PEDESTRIAN WIND ENVIRONMENT STATEMENT THE WHARF SITE, WENTWORTH POINT

W382-54F03(REV0)- WS REPORT

5 FEBRUARY 2014

This report is in relation to the proposed development known as Wharf Site, Wentworth Point, and is located at 1 Burroway Road, Sydney Olympic Park. This report presents an opinion on the likely impact of the proposed design on the local wind environment to the critical outdoor areas within and around the subject development. The effect of wind activity is examined for the three predominant wind directions for the Sydney region; north-easterly, southerly and westerly winds. The analysis of the wind effects relating to the proposal was carried out in the context of the local wind climate, building morphology and land topography. The conclusions of this report are drawn from our extensive experience in this field and are based on an examination of the architectural drawings which have been prepared by the project architect Rice Daubney, received during January and February 2014. No wind tunnel tests have been undertaken for the subject development, and hence this report addresses only the general wind effects and any localised effects that are identifiable by visual in

2 LEVEL 3  
1 : 500

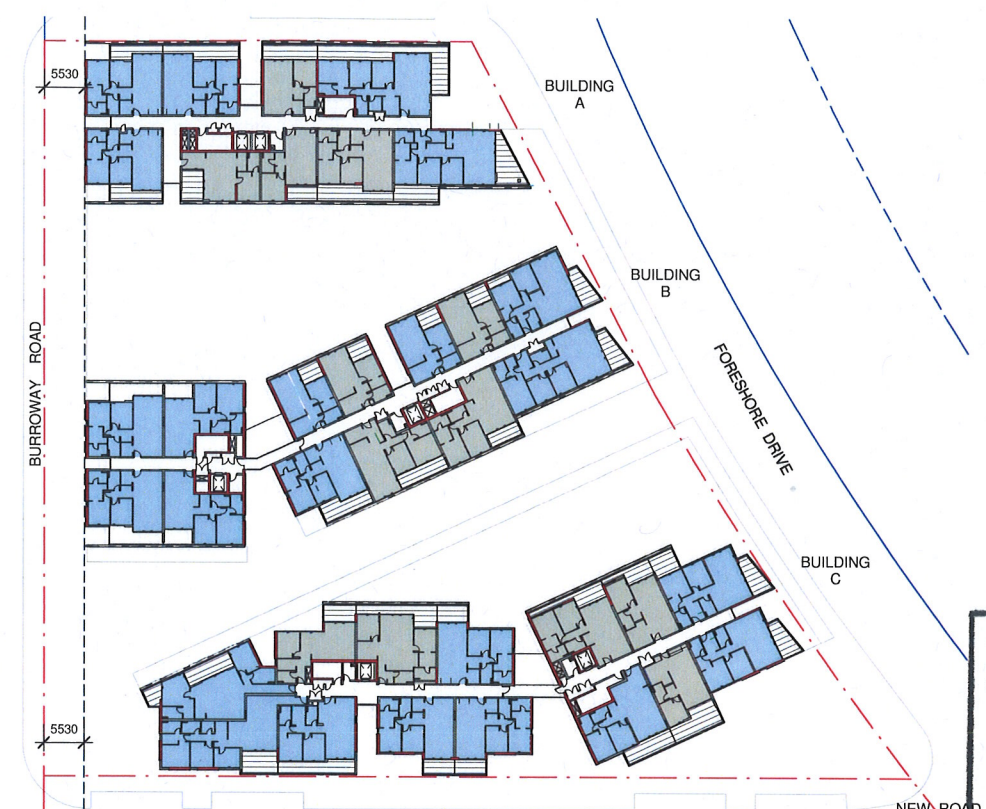
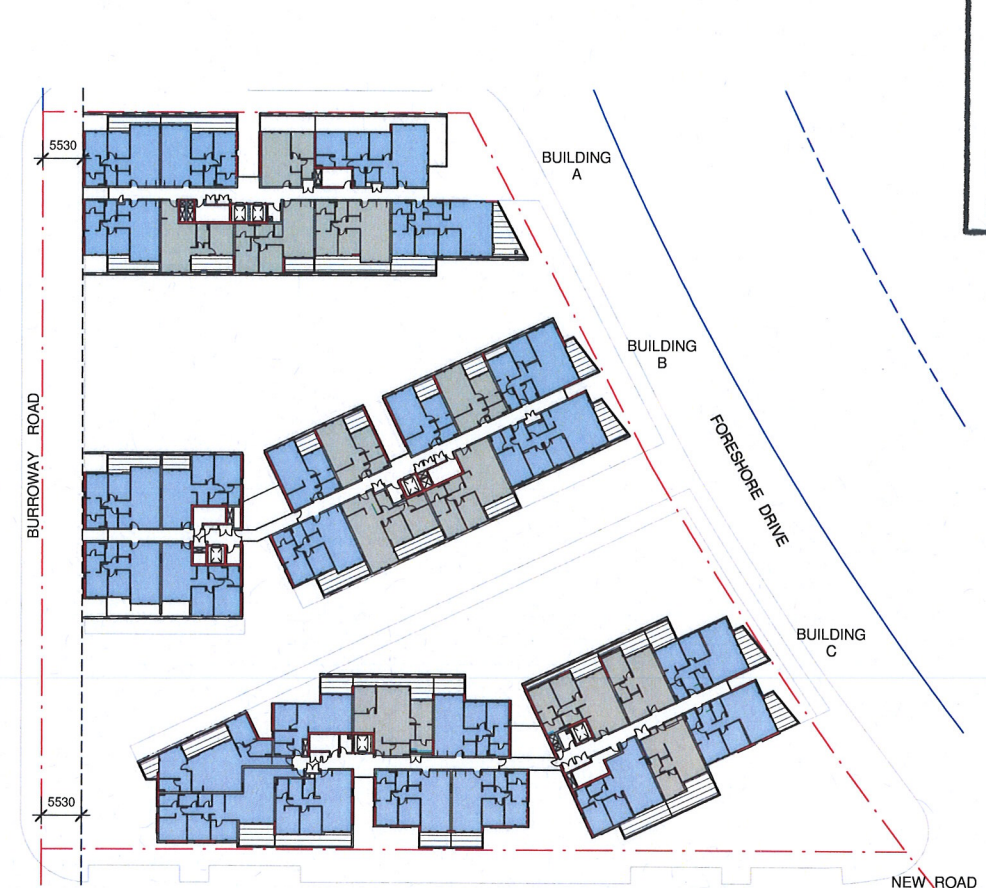
- For the north-western corner balconies of Building A, on Levels 2 to 5, it is recommended to include some full-height sunshade louvred screens on the western aspect. These screens could be on rails and able to be moved along the edge of the balcony slab by the occupants of those apartments, and can be used to provide some protection to the balcony area on days when there is a strong wind coming from the west.
- For the balconies on the northern aspect of Building A, on Levels 2 to 5, it is recommended to have a solid screen (at least 2m high) on the western side of those balconies to provide protection to the balcony area on days when there is a strong wind coming from the west.
- For the larger balcony at south-western aspect of Building A, on Levels 2 to 9, it is recommended to have solid screens (at least 2m high) on either side.

The abovementioned treatments are also presented in Figure 4c in the form of a marked-up plan drawing. With the inclusion of these treatments, and solid balustrades (ie: glass, concrete, etc) for all private balconies and terraces of the development, it is expected that adequate wind conditions will be achieved for all private balconies and terraces of the development.
